**ADC Planning Consultation
Conservation/Design Officer Response**

Application Number	EG/66/17/L
Address	The Wilkes Head Church Lane Eastergate PO20 3UT
Description	Permission to retain a marquee for a period of three years
Case Officer	Mr R Temple
Date	31.10.17

Drawing 3 - Floor Plan and Elevations

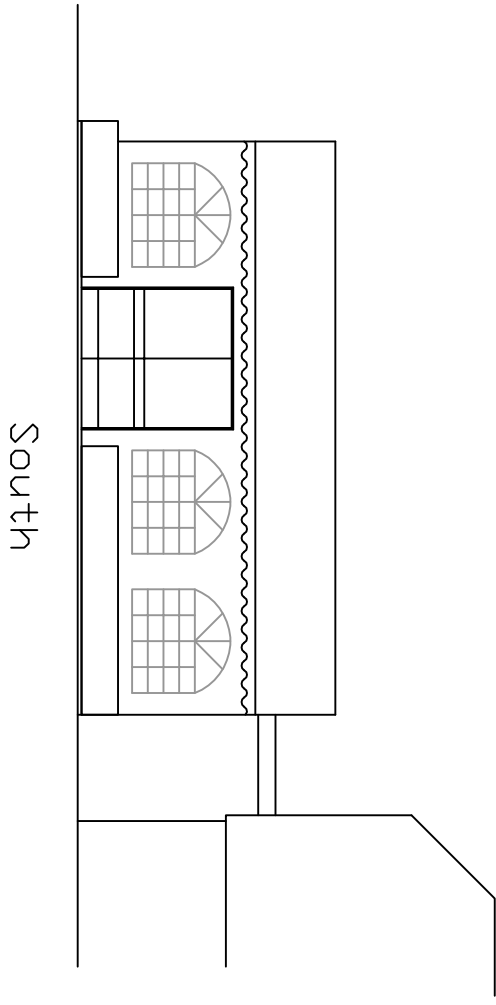
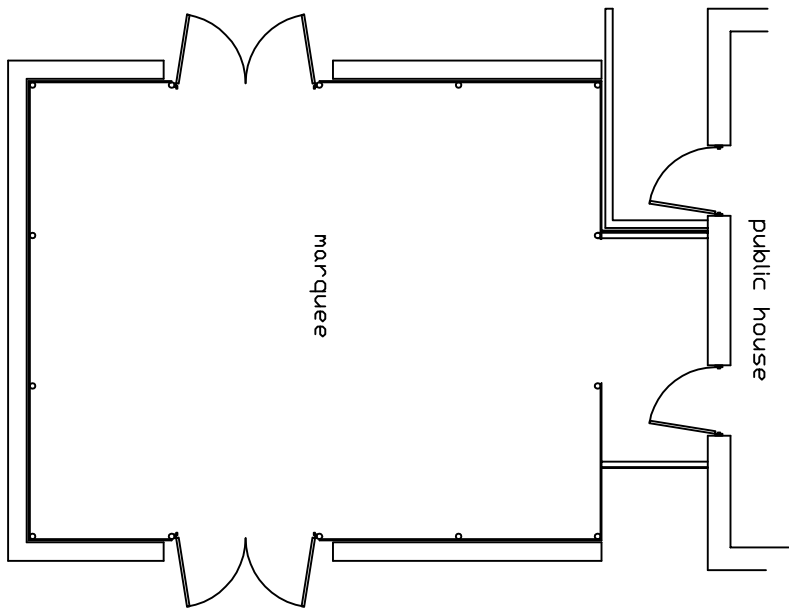
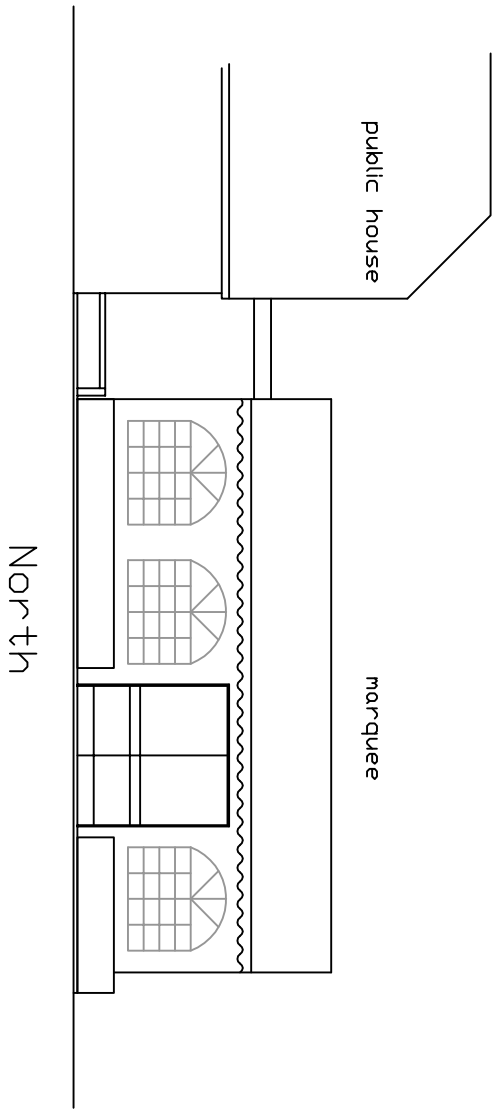
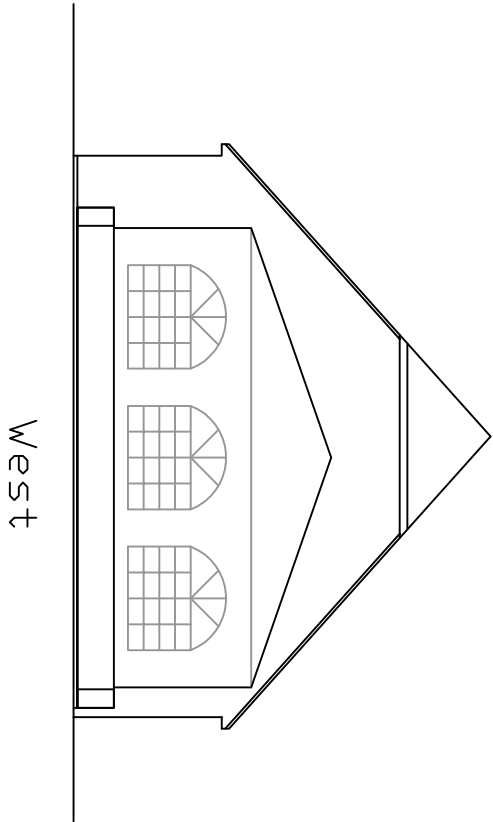
The application relates to retention of a marquee, which it is noted had been in place since 2011. While there is no objection in conservation terms as the proposal is unlikely to cause physical harm to the heritage asset, it is considered that the mass and materials of the marquee are detrimental to the appreciation of the heritage asset and its immediate setting.

I do not object to this proposal, subject to a time limit of three years, should permission be granted.
